Response to Deadline 3 Submission – Specific Hearing Day 3 and Appendices.

SP Manweb's Comments on Responses to First Written Questions – Deadline 2 Submission.

Figure 11.12 Duration of Negative Impacts of Proposed Development

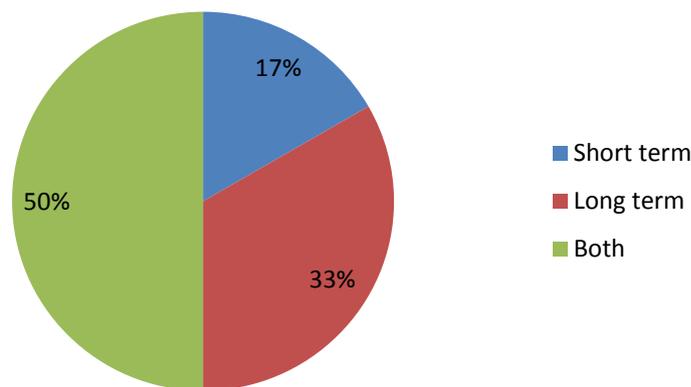
It is totally evident that the questionnaire is biased because as a direct comparison Question 19 asks: 'If you think there will be negative impacts, do you think they will be short, medium or long term?' However, there is no suggested negative answer to this question.
